From: Sarah Burrow <Sarah.Burrow@arun.gov.uk>
Sent: 23 December 2020 10:26
To: Planning.Responses <Planning.Responses@arun.gov.uk>
Subject: RE: Planning Consultation on: LU/284/20/PL

Engineers Comments Regarding Surface Water Drainage

Application No: LU/284/20/PL
Registered: 13th November 2020
Site Address: 54 Arundel Road Littlehampton BN17 7DD
Grid Reference: 502732 102451
Description of Works: Demolition of 3 No. garages & erection of a four-room house of multiple occupation with shared facilities & parking for 3 cars (resubmission of LU/125/19/PL).

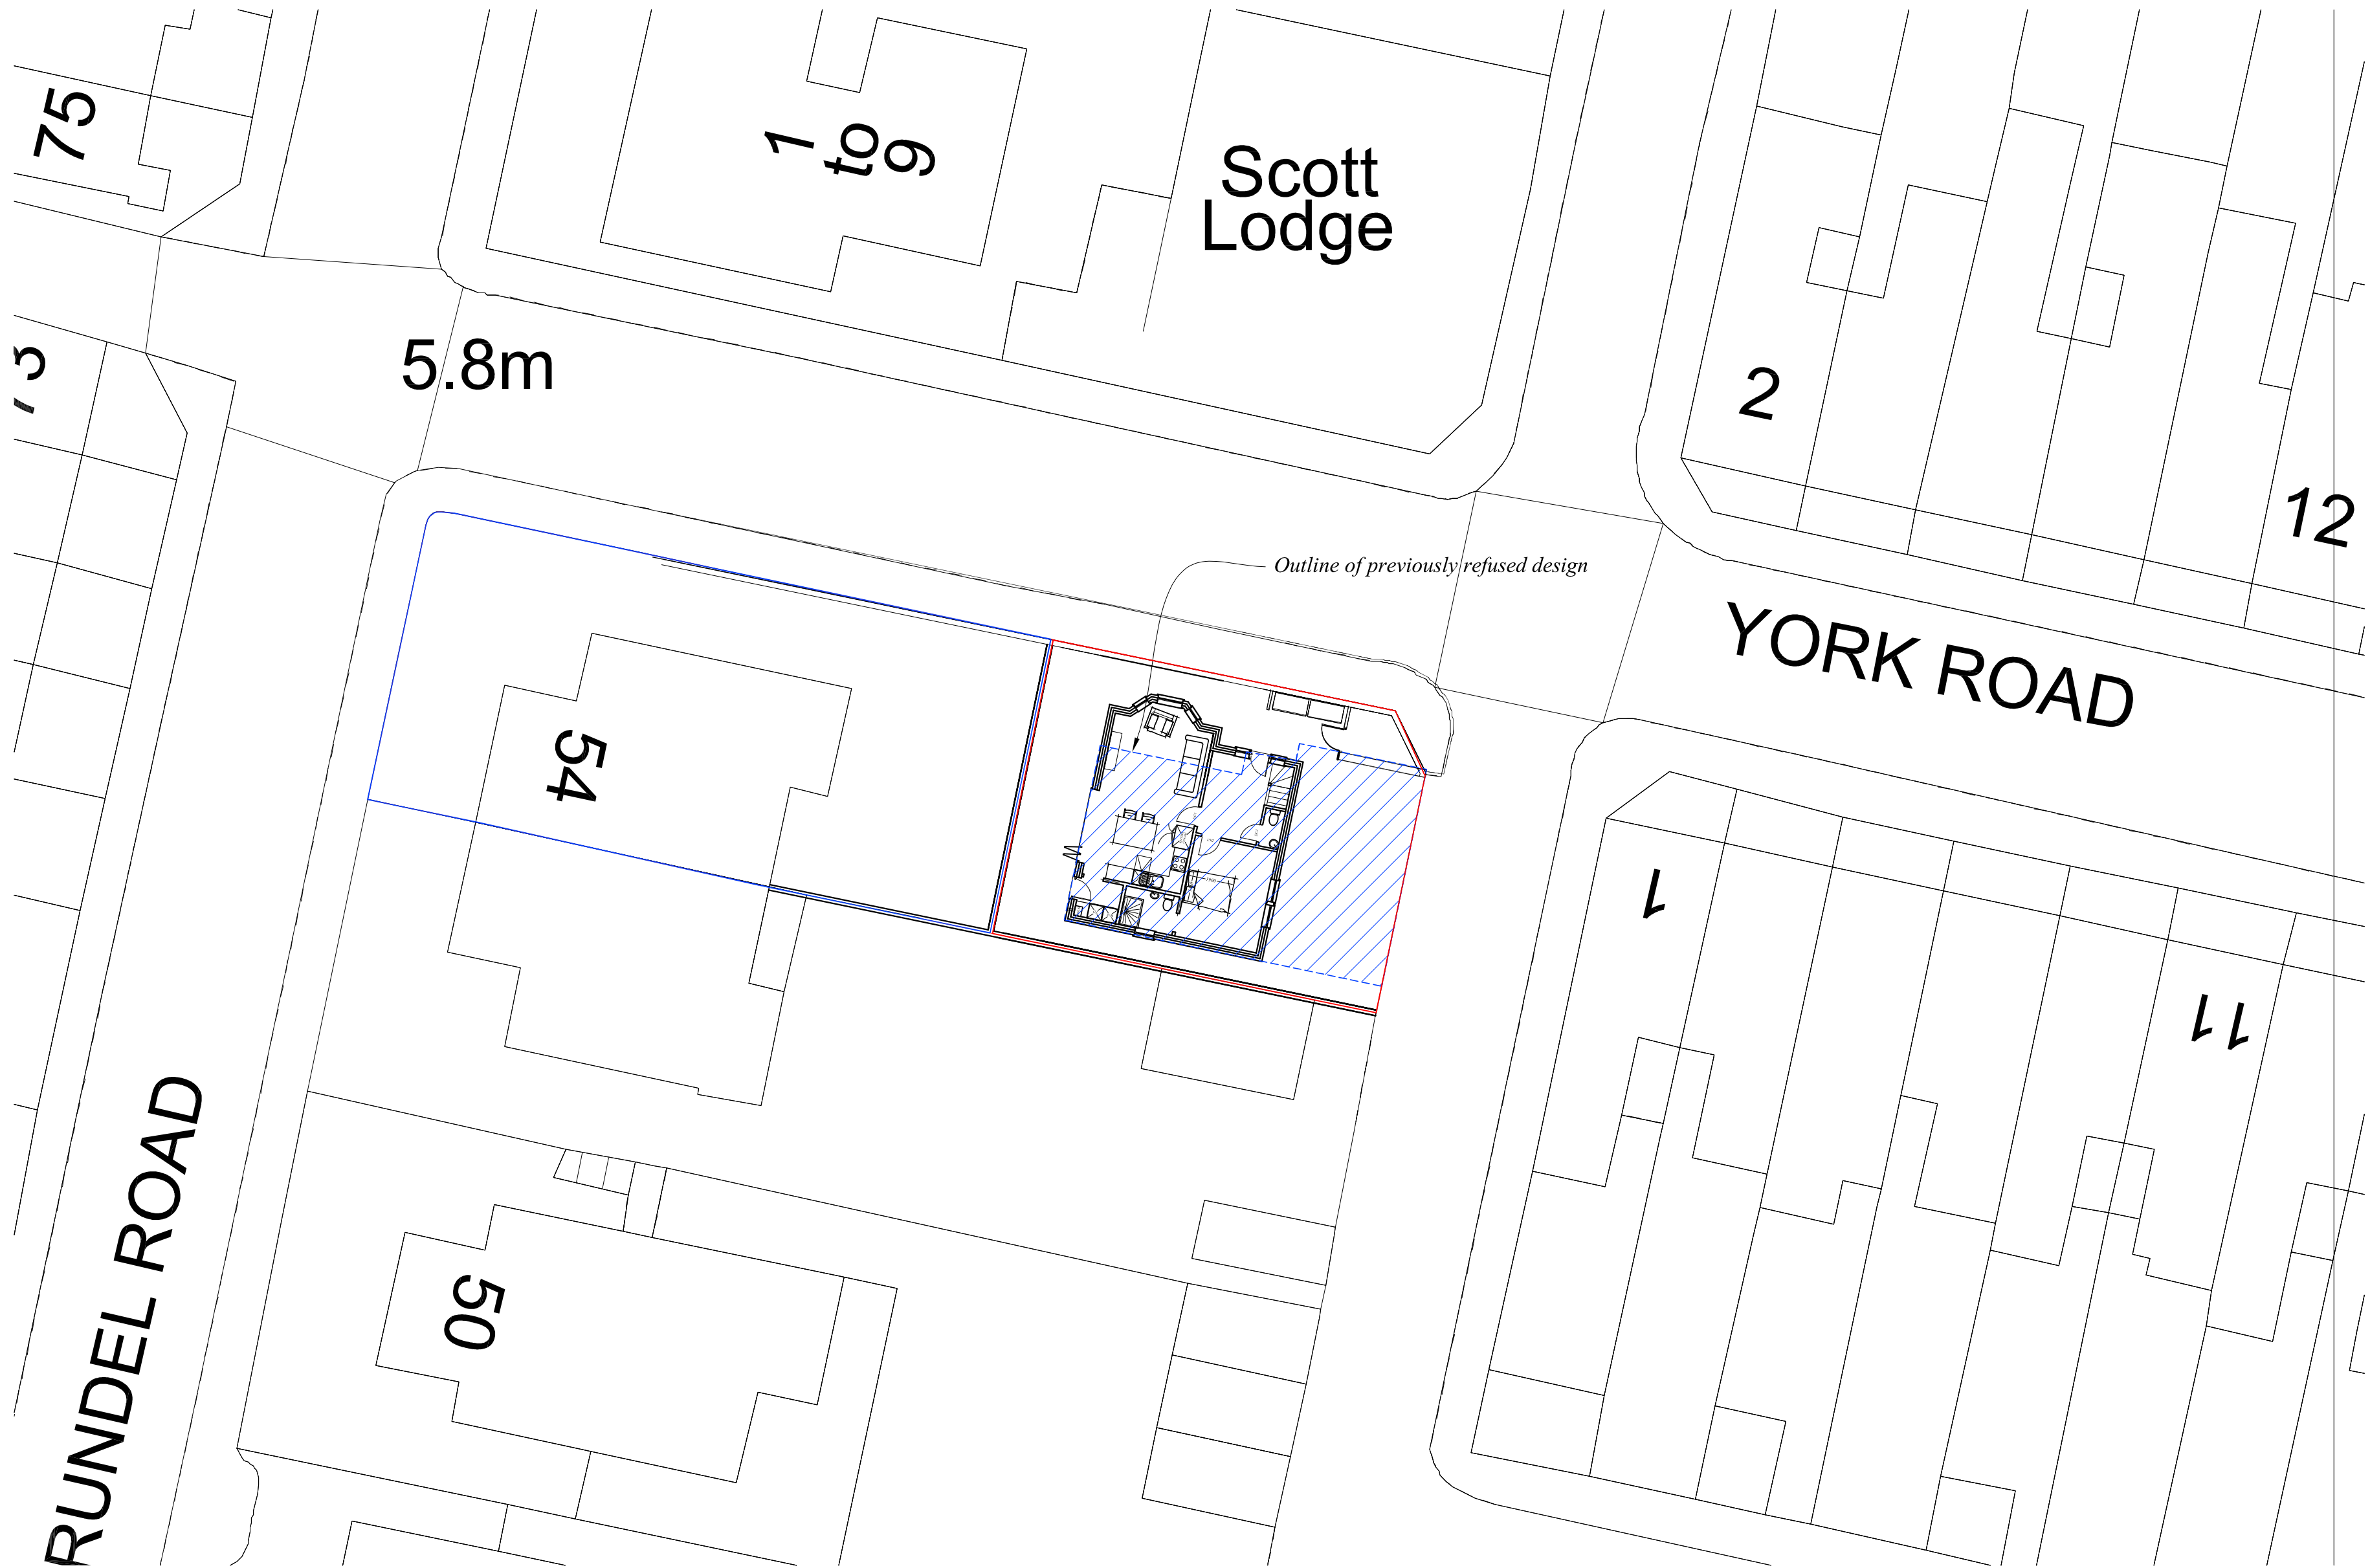
The hierarchy for sustainable drainage should be followed and soakaways fully investigated. However, despite reducing the mass of the building from application LU/125/19/PL there still appears to be insufficient room for surface water drainage within the curtilage of the new site. Soakaways must be located 5m from buildings, and should be located 2.5m from property boundaries.

Mapping indicates that Arundel Road is at risk of surface water flooding. There are no other sources for surface water disposal except disposal to the foul sewer. This should be an absolute last resort, will be resisted by ourselves and may be turned down by the sewerage undertaker.

To overcome my objection the applicant should complete winter groundwater monitoring and winter infiltration testing and complete calculations to assess the size of structures required. A rough plan should be formed showing where these structures can be provided within the proposed layout. Detailed design of the system can be left until discharge of conditions where the applicant should provide the level of information stated within our checklist <https://www.arun.gov.uk/drainagechecklist>.

"Development shall not commence, other than works of site survey and investigation, until full details of the proposed surface water drainage scheme have been submitted to and approved in writing by the Local Planning Authority. The design should follow the hierarchy of preference for different types of surface water drainage disposal systems as set out in Approved Document H of the Building Regulations, and the recommendations of the SuDS Manual produced by CIRIA. Winter groundwater monitoring to establish highest annual ground water levels and winter Percolation testing to BRE 365, or similar approved, will be required to support the design of any Infiltration drainage. No building / No part of the extended building shall be occupied until the complete surface water drainage system serving the property has been implemented in accordance with the agreed details and the details so agreed shall be maintained in good working order in perpetuity."
